SYDNEY OLYMPIC PARK AUTHORITY DESIGN REVIEW PANEL – ADVICE SHEET

Project	Sites 2A and 2B – Australia Ave, Sydney Olympic Park	
Presentation / Review Date	31 October 2018	
Panel Present	Ingrid Mather Caroline Pidcock Michael Harrison	JMD Design (Chair) Pidcock Architects Architectus
COI Declaration	None	
Also Present	Alix Carpenter, Ben Woods, Dylan Sargent and Catherine Modini (SOPA) Daniel West and Candice Pon (Ethos Urban) Bassam Afflak and Michael Azar (Ecove)	
Presenters	James Fitzpatrick (Fitzpatrick + Partners) Matthew Mar (Fitzpatrick + Partners) Michael Barnett (Arcadia)

5.10 *Ficus macrophylla* – Section East-West

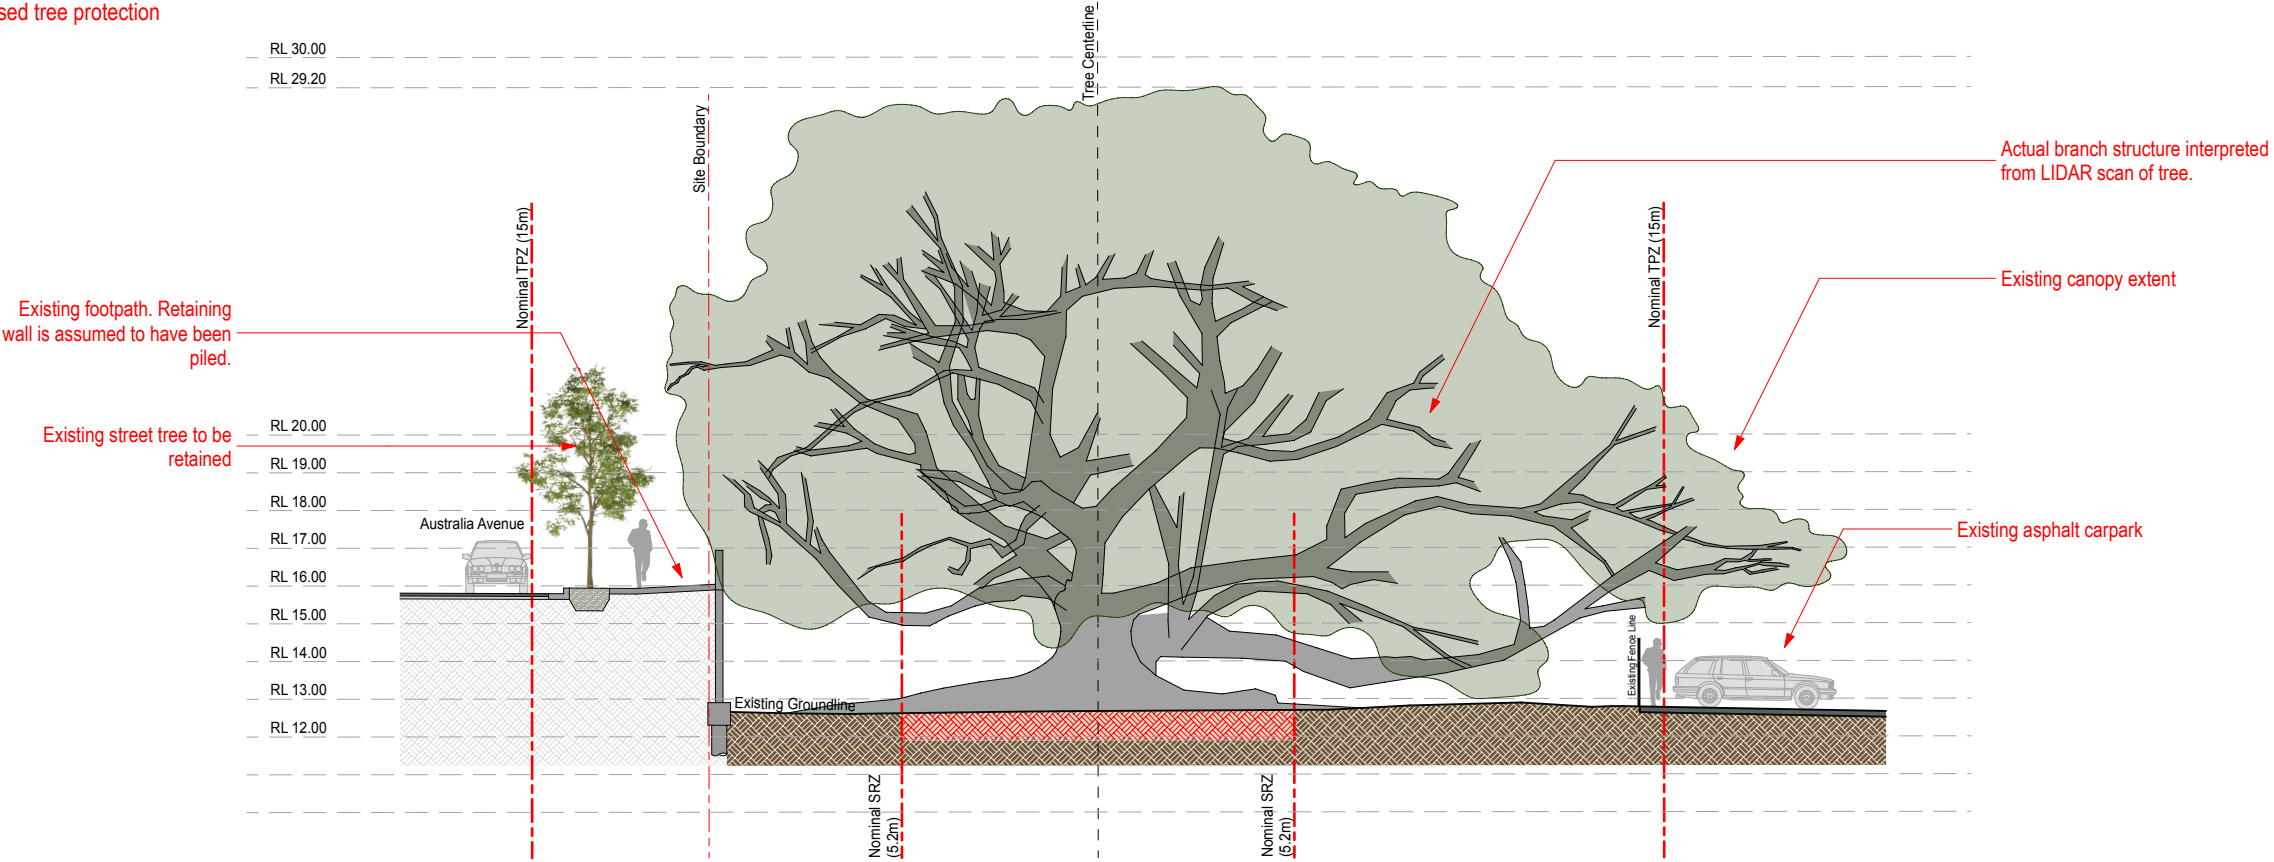
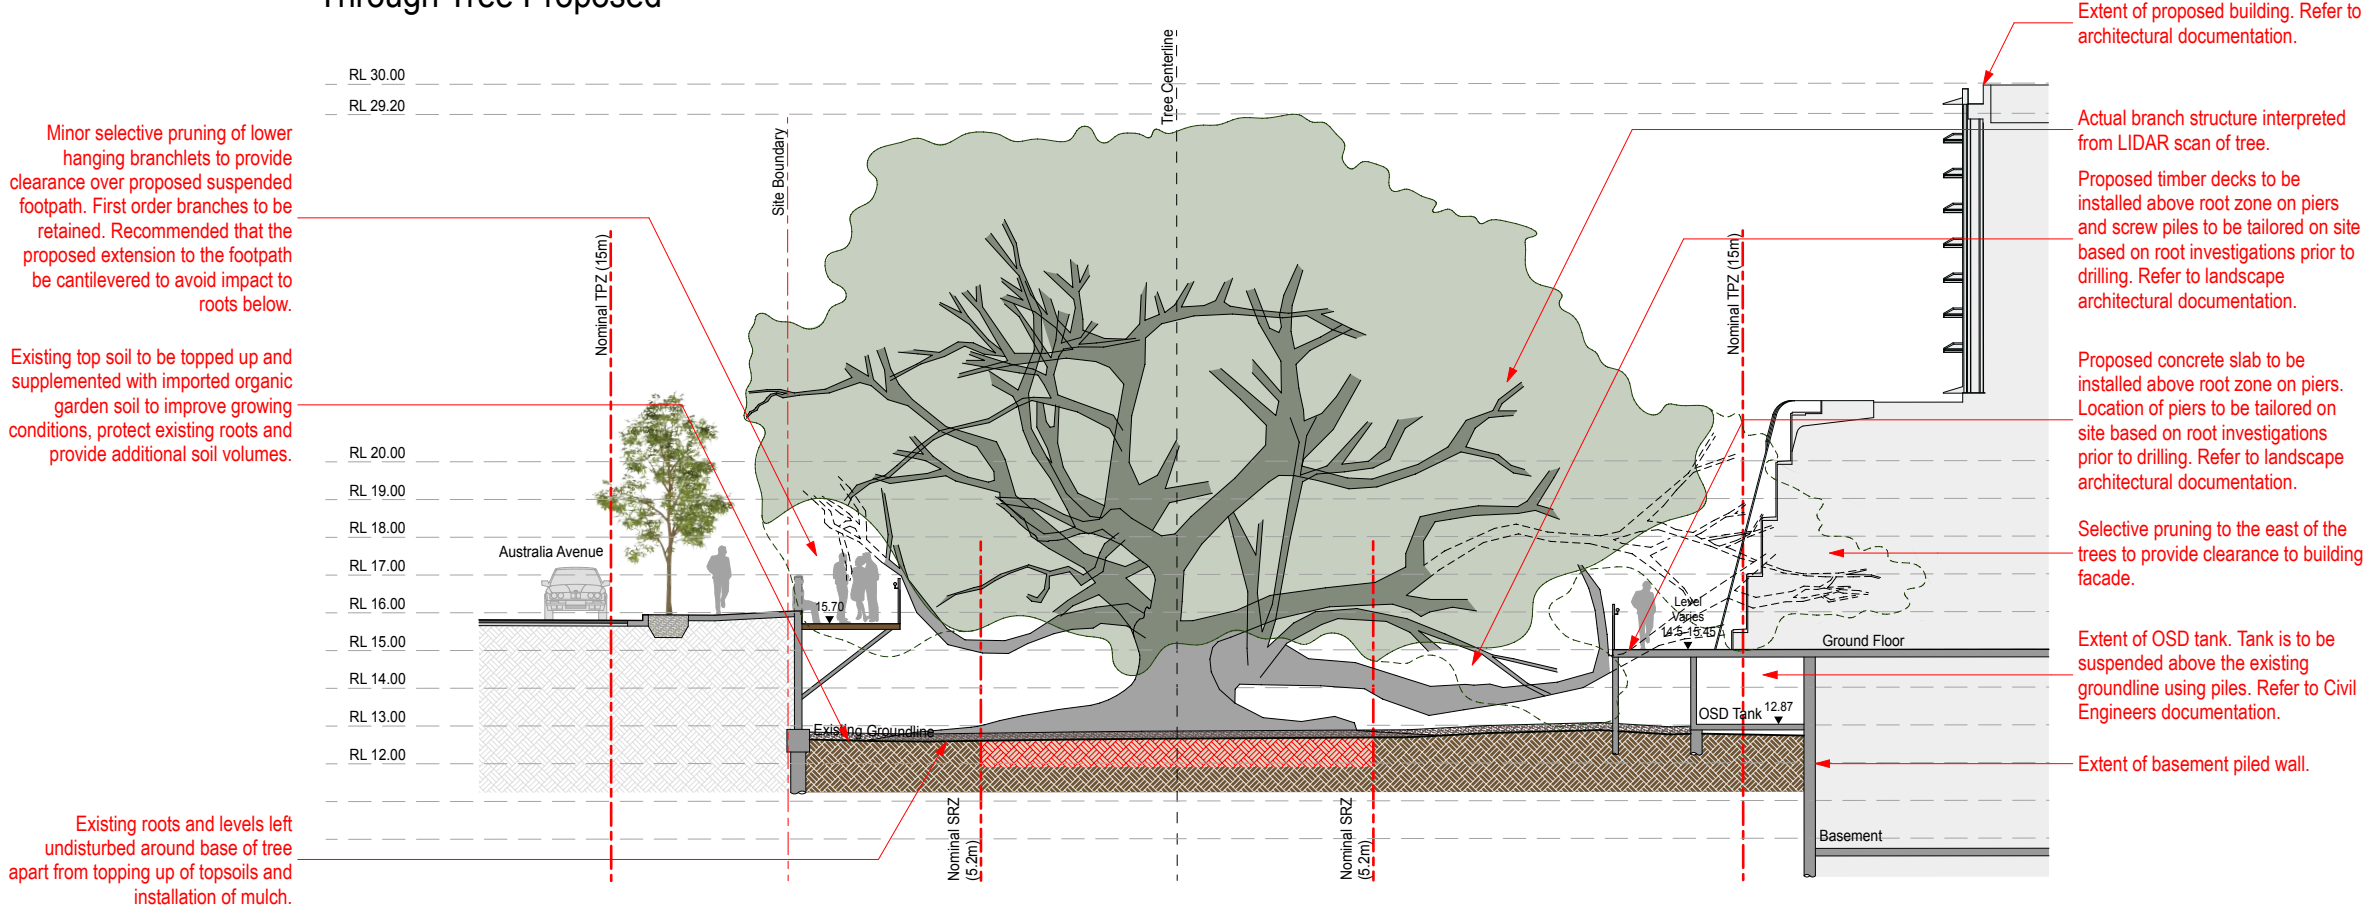
- stepped grass terraces from Australia Avenue to the forecourt of the building on Site 2A;
- a preferred option for the treatment of the fig tree on Site 2A involving raising the tree by 2.8m and construction of timber decking around the buttress roots;

- three alternative options for leaving the fig tree in place, including:
 - a sunken deck,
 - a 'net-scape', and
 - a sunken deck and terrace area;
- introduction of brick 'terrain' seating between Australia Avenue and the building on Site 2B;

- f. Whether lifting the fig tree at the north-western corner is the best outcome for the tree and the site. The Panel strongly recommended that SOPA obtain a second opinion as to whether the lifting of the tree is viable; and
